Re: Hagstrom Residence Critical Areas Report, Response to Peer Review Comments

The Watershed Company Reference Number: 160735

This letter represents our responses to the concerns and recommendations provided by the City's Peer Reviewer related to the recently prepared mitigation plan and Critical Areas Report for your property located at 7428 SE 71st Street in Mercer Island, Washington. The comments were provided in a June 8, 2017, letter from Environmental Science Associates (ESA) (*Hagstrom Review CAO17-004*). ESA's comments and recommendations are listed in italics below. Our response to the comments follow in standard font.

JOB NUMBER: 160735  
SHEET NUMBER: W3 OF 7

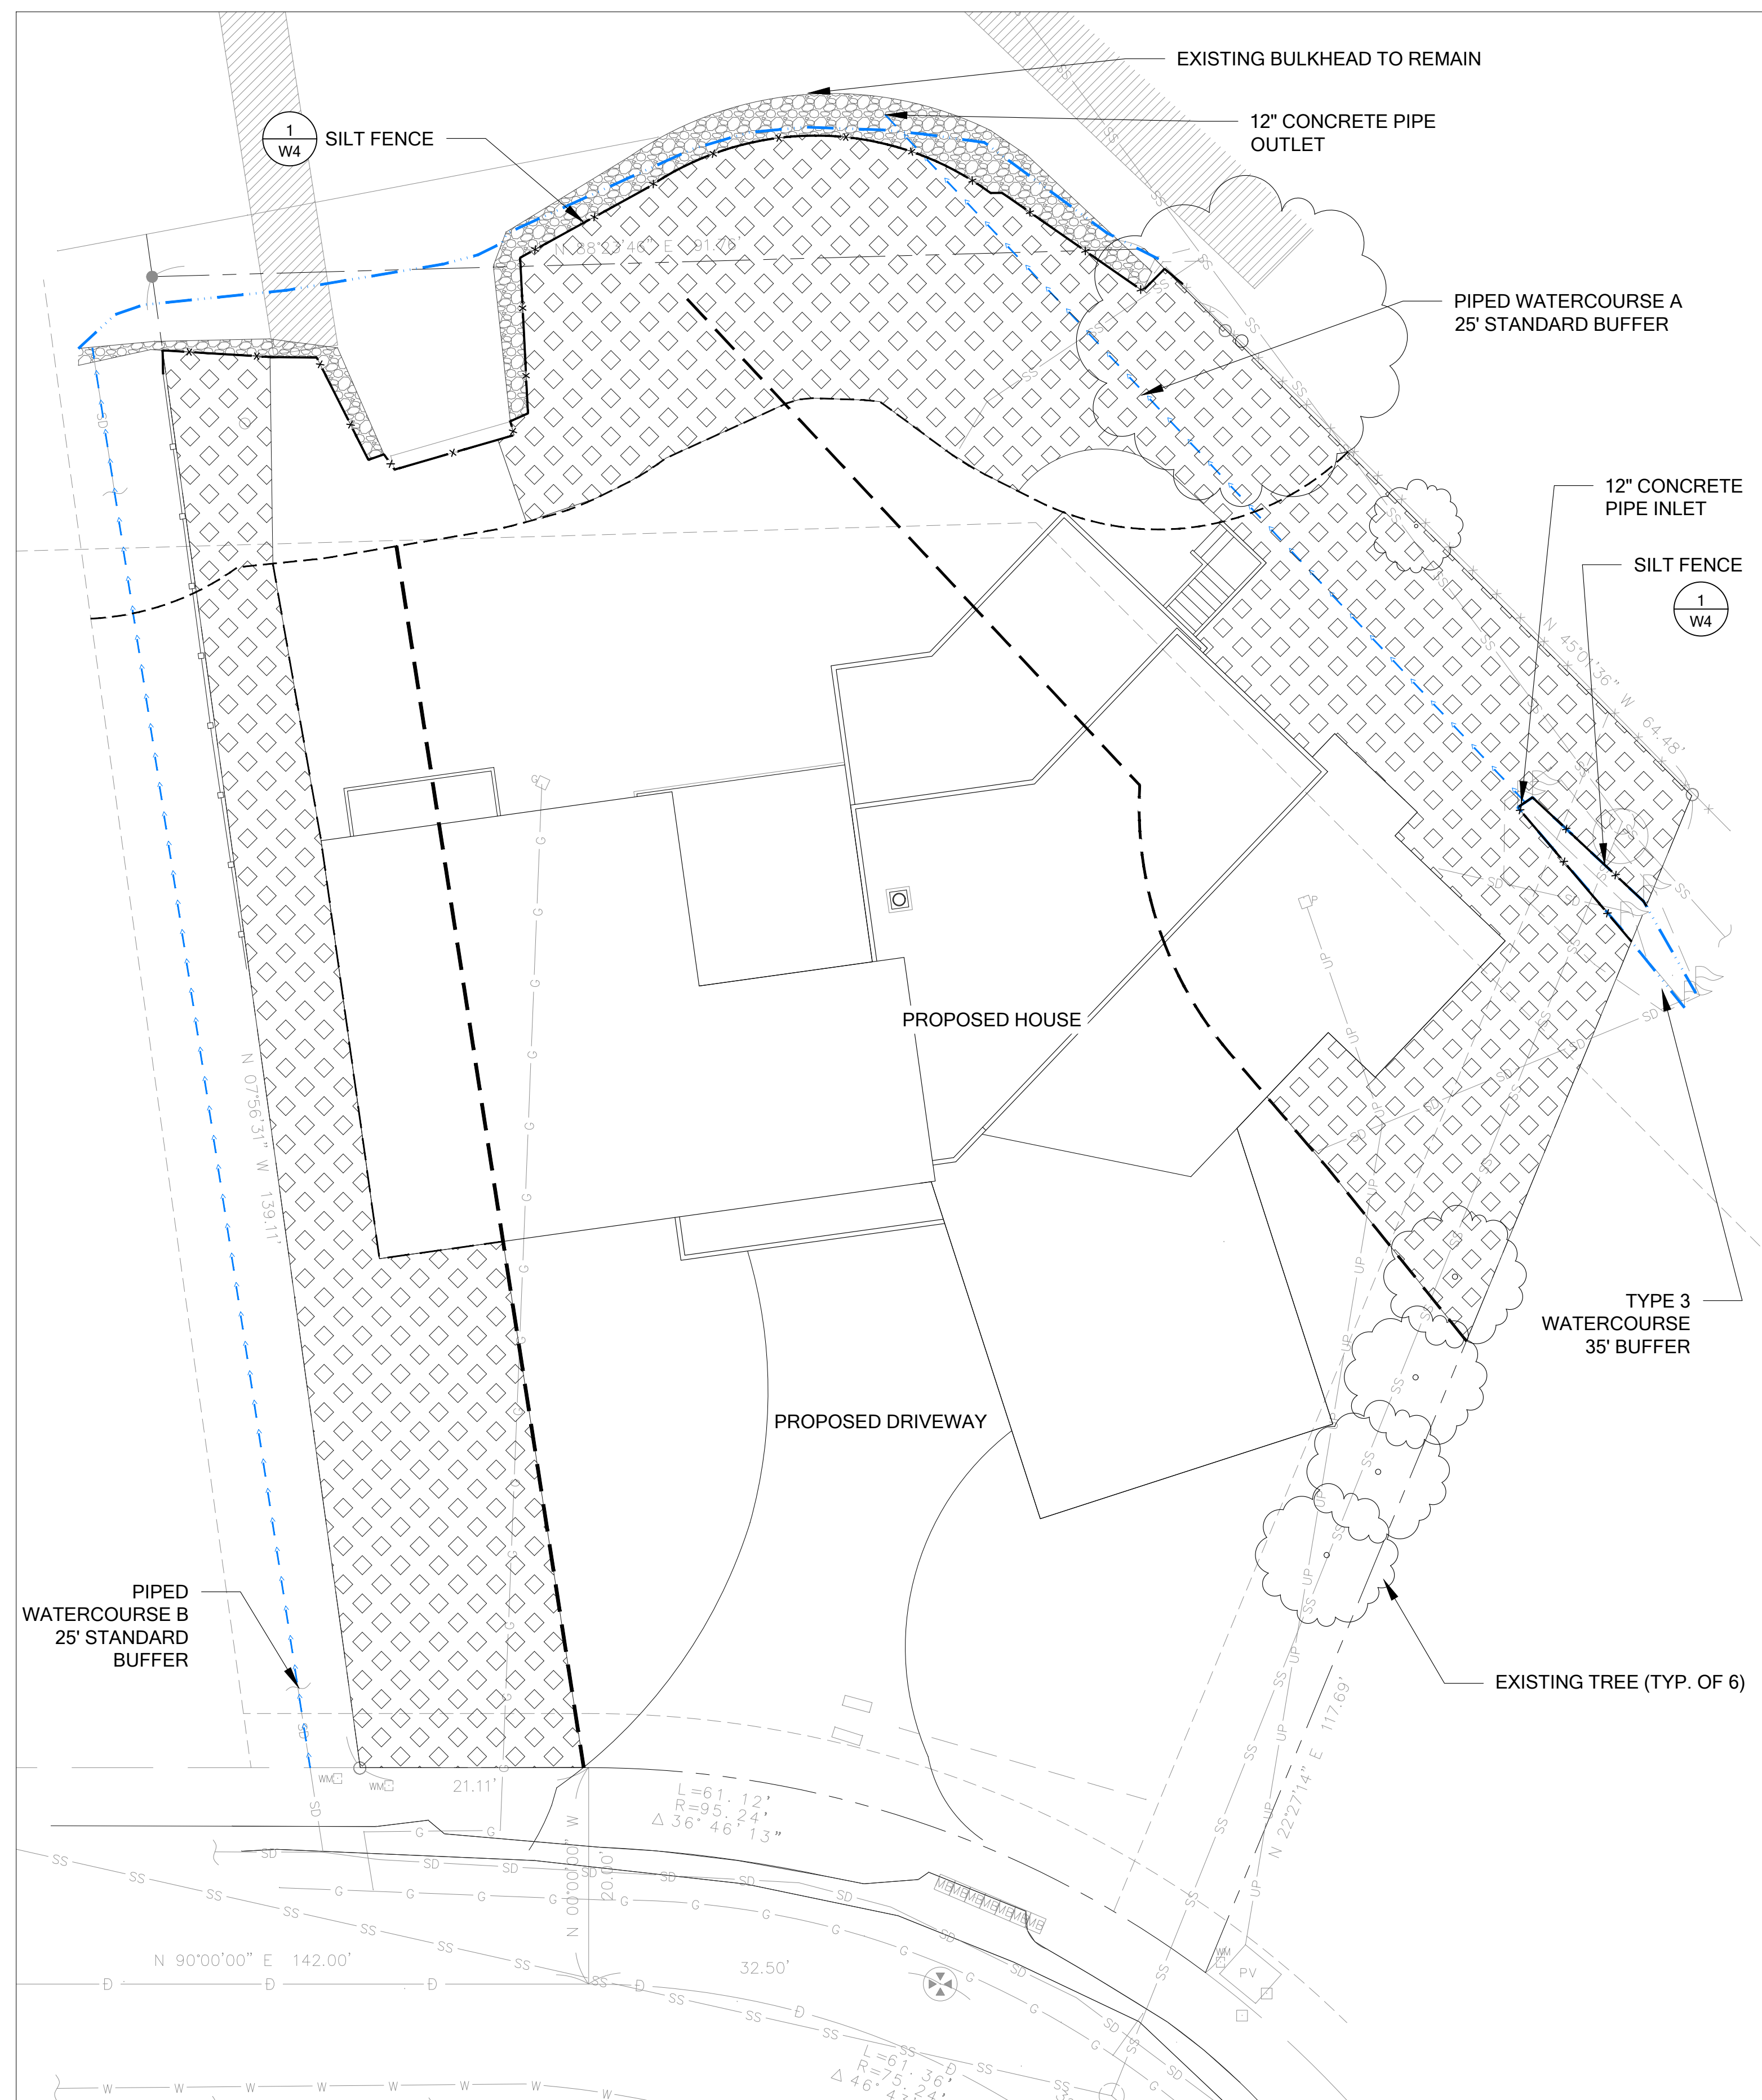
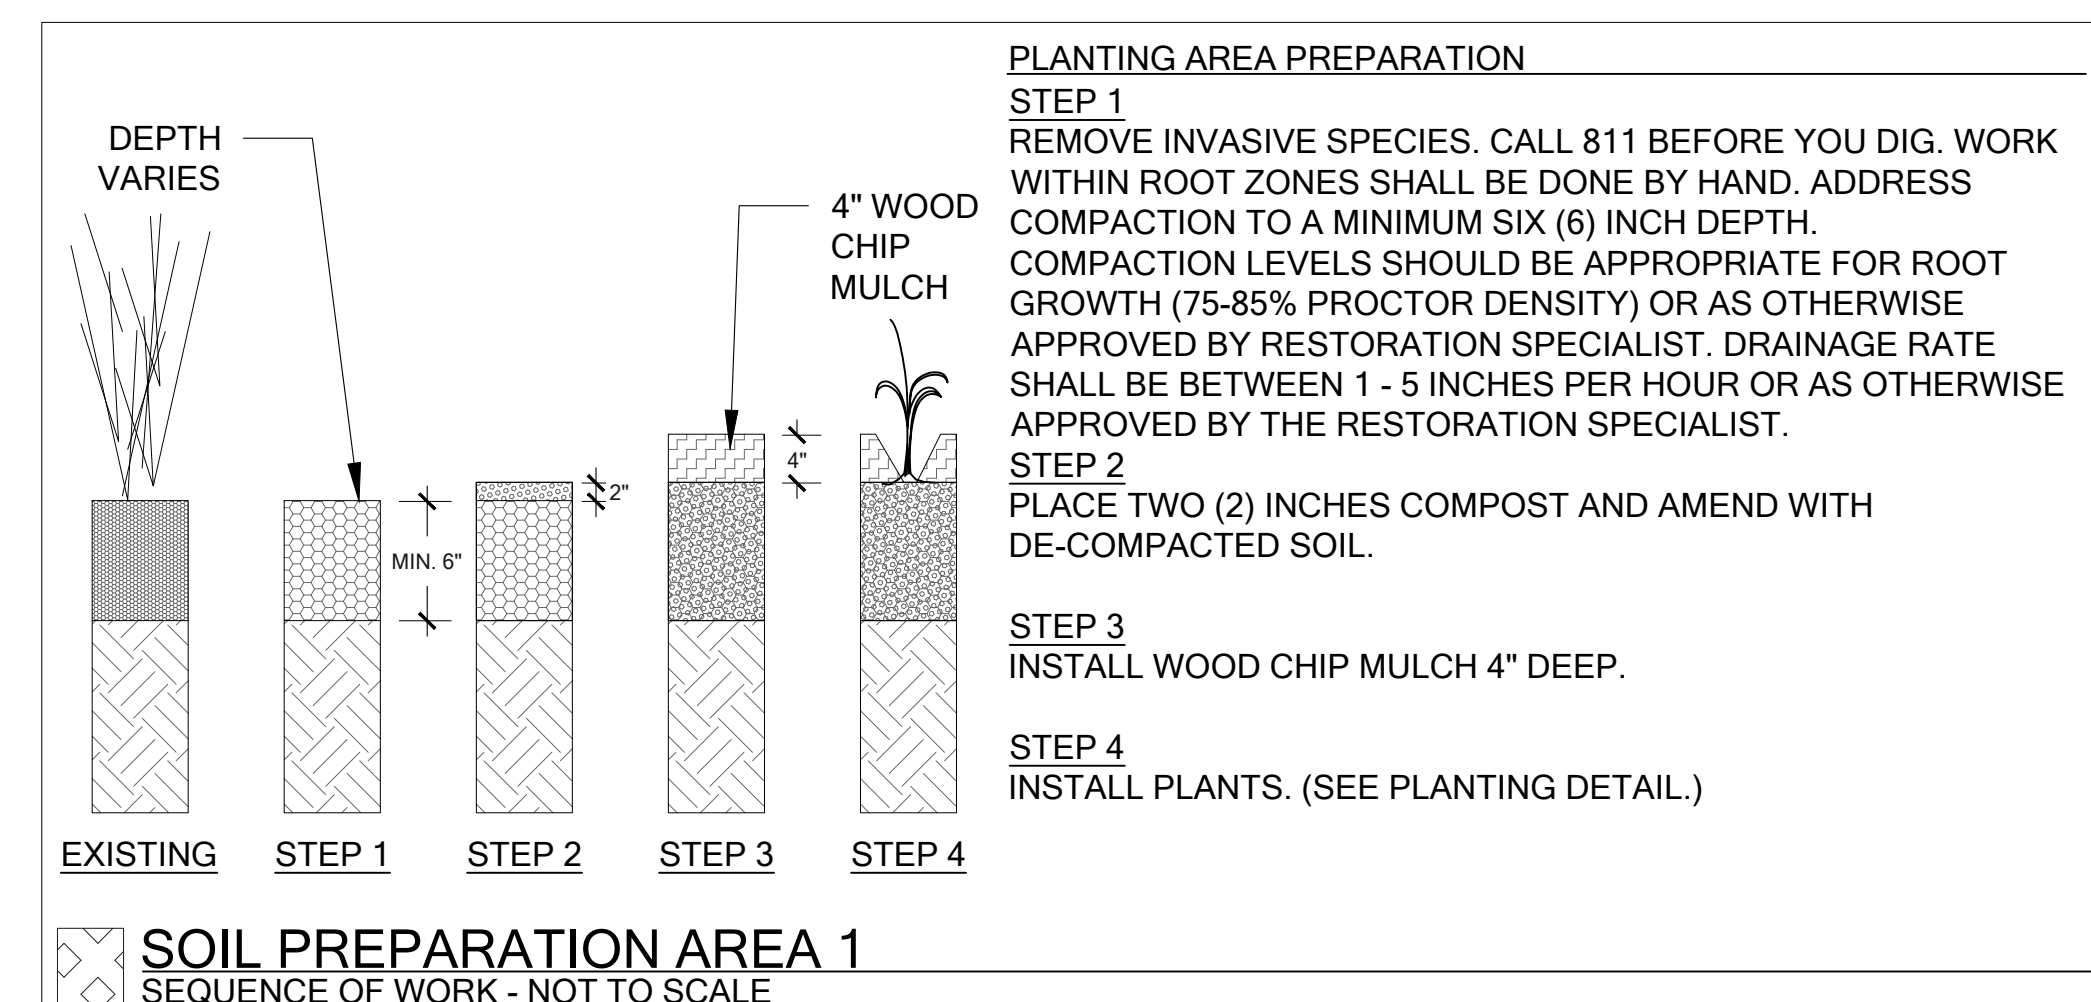
Concern – On sheet W3 of the drawing set the legend lists the buffer enhancement area for shoreline setback mitigation at 1,819 SF, but page 10 (section 5.0) of the critical area study lists that enhancement area at 1,908 SF.

The correct area of shoreline setback mitigation area is 1,908 SF. The CAR has been revised to correct the inconsistency.

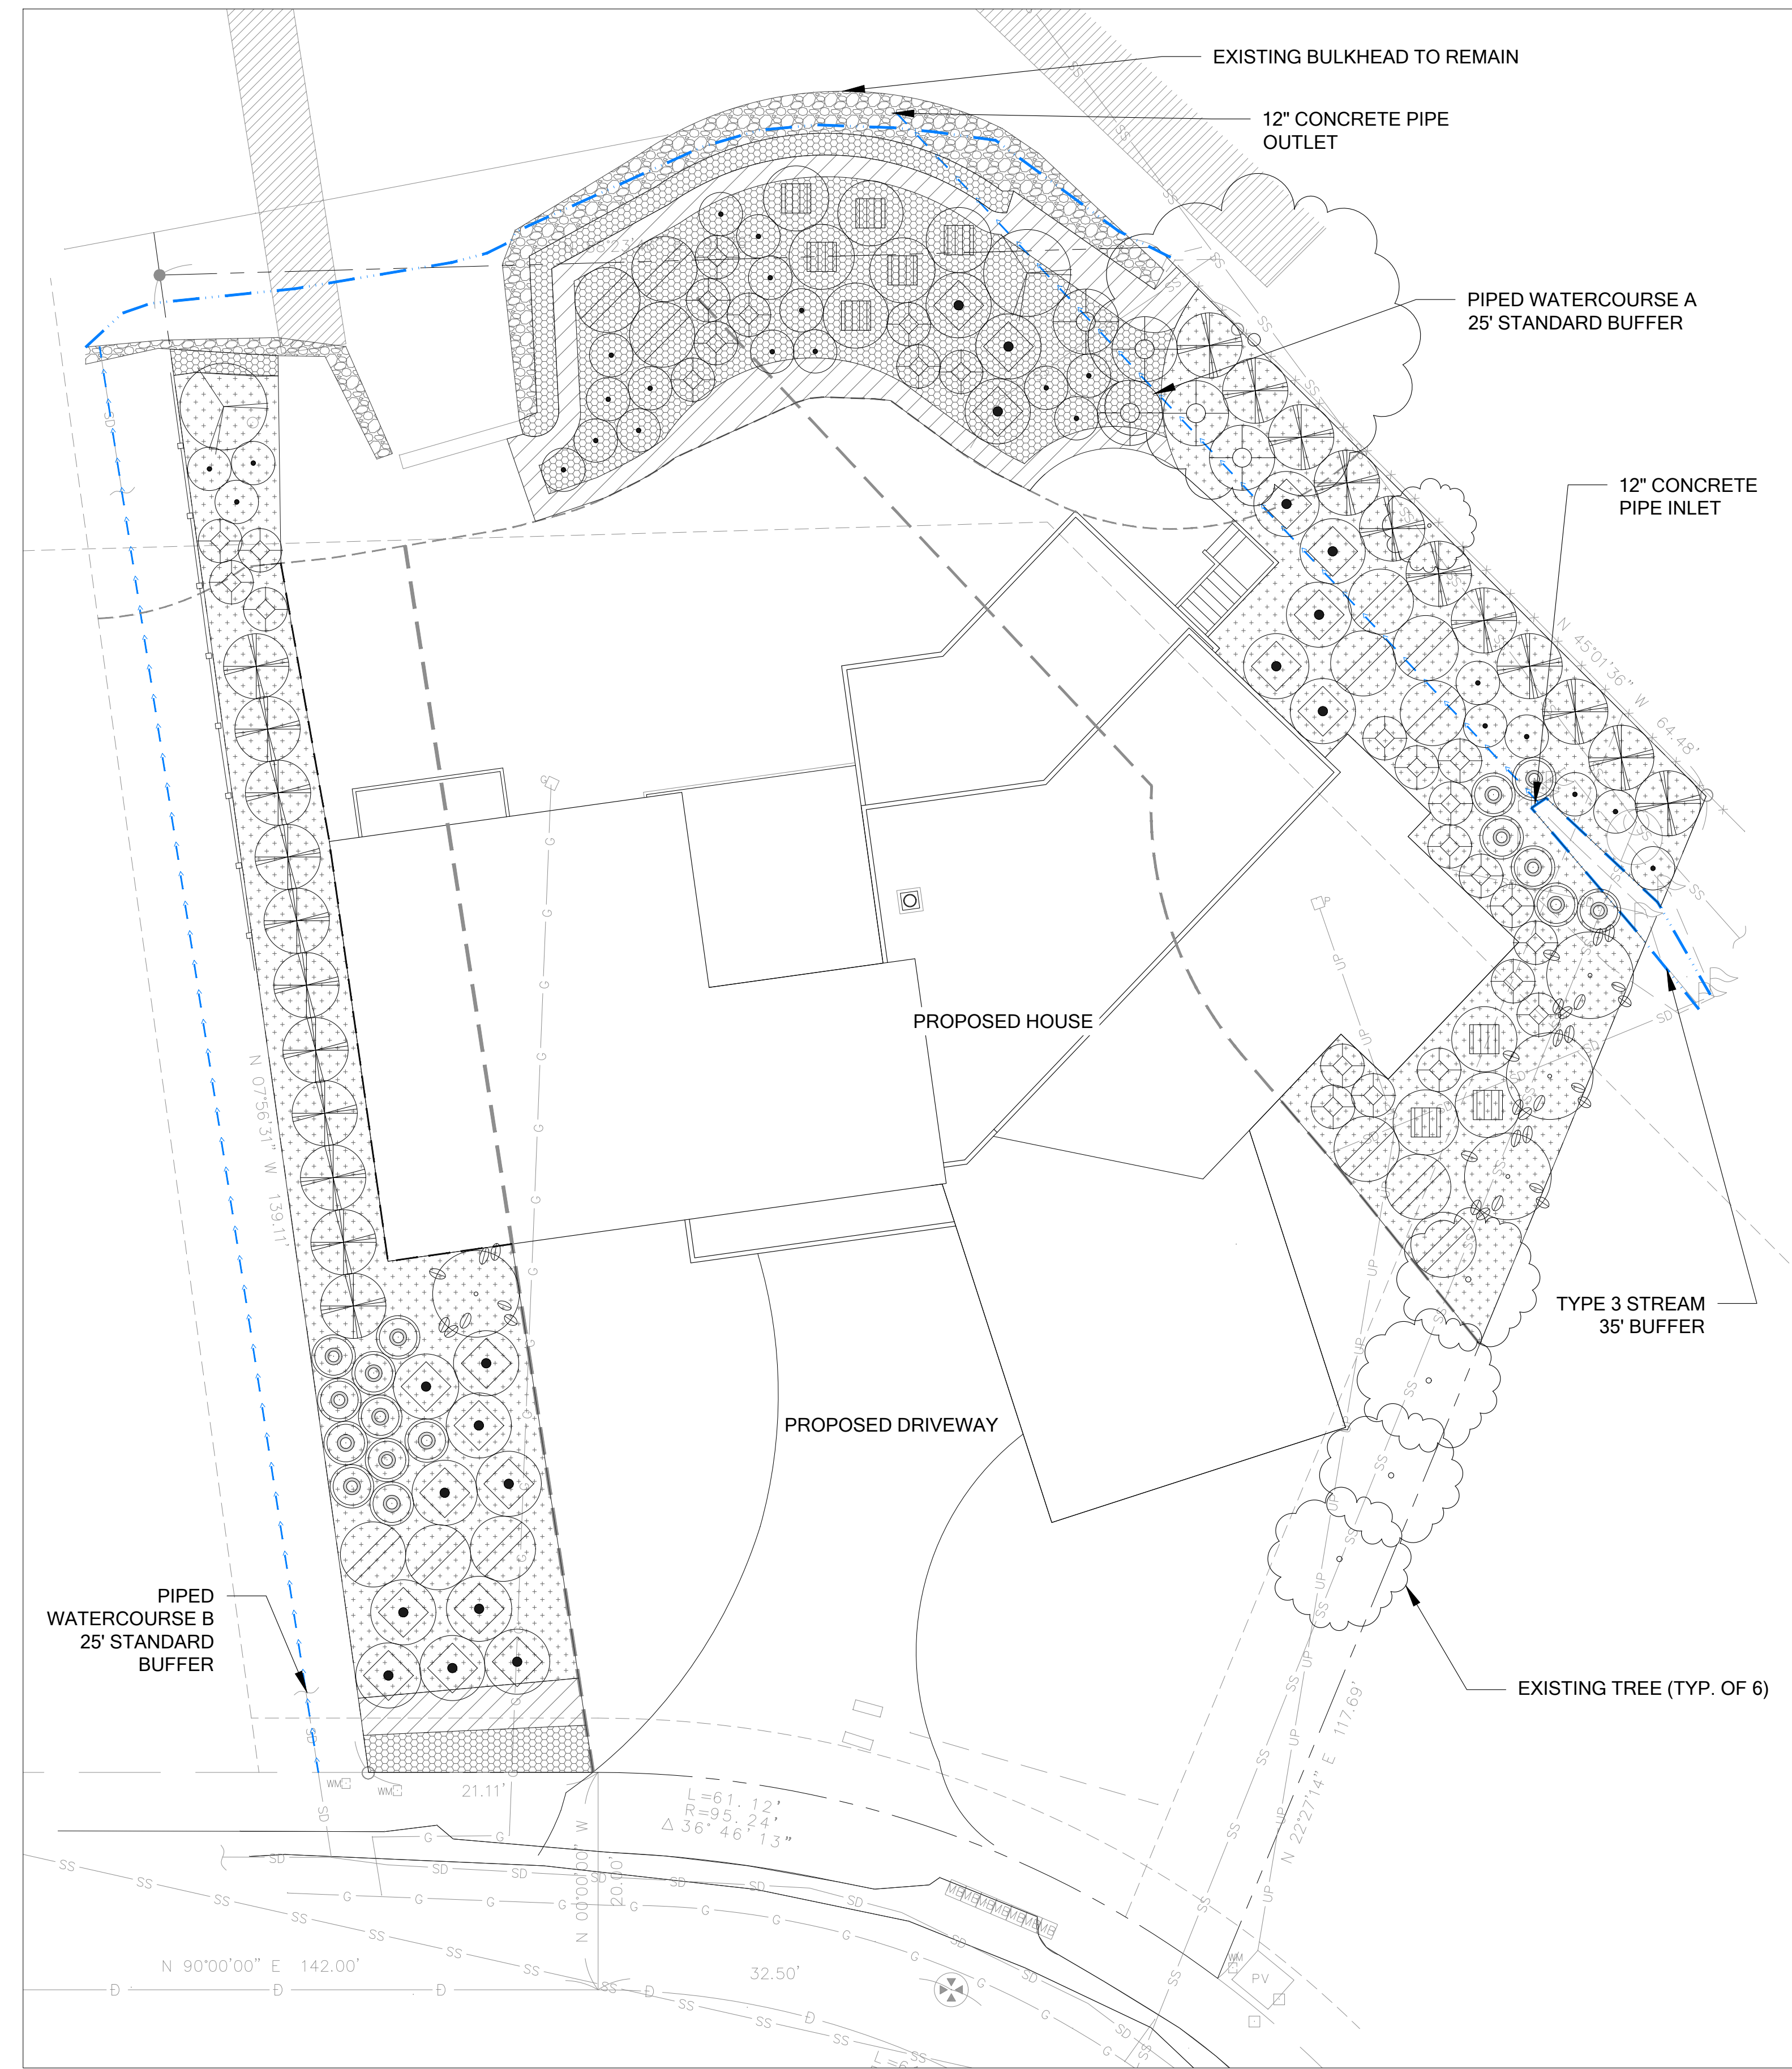
On the "second" sheet W4 of the drawing set (assuming it is meant to be sheet W5) there are ten (10) shrubs listed in the planting schedule, but on page 14 of the critical area study (section 6.1) it states that "nine native small tree/shrub species and five native groundcover species are proposed in the mitigation area."

Also on "second" sheet W4 hatched areas for groundcovers are shown beneath proposed shrub plantings. If the quantities listed for groundcovers in the planting schedule are calculated to be

planted at 24" O.C. across the entirety of these hatched areas, this would result in too many plants being planted on the site. This could be mitigated if the quantities been adjusted to leave room for the other plants on the plan.

There correct number of proposed shrub plantings is ten. The CAR has been revised to correct the inconsistency. The duplicate plan sheet numbers have been corrected.

The planting quantities and/or densities have been recalculated as requested. Groundcovers in the watercourse buffer enhancement areas, which include sword fern and low Oregon grape, will be spaced at 48" on center. Groundcovers in the shoreline buffer enhancement area, including kinnikinnick, western larkspur, and Roemer's fescue, are smaller species, which will be installed at 36" on center.
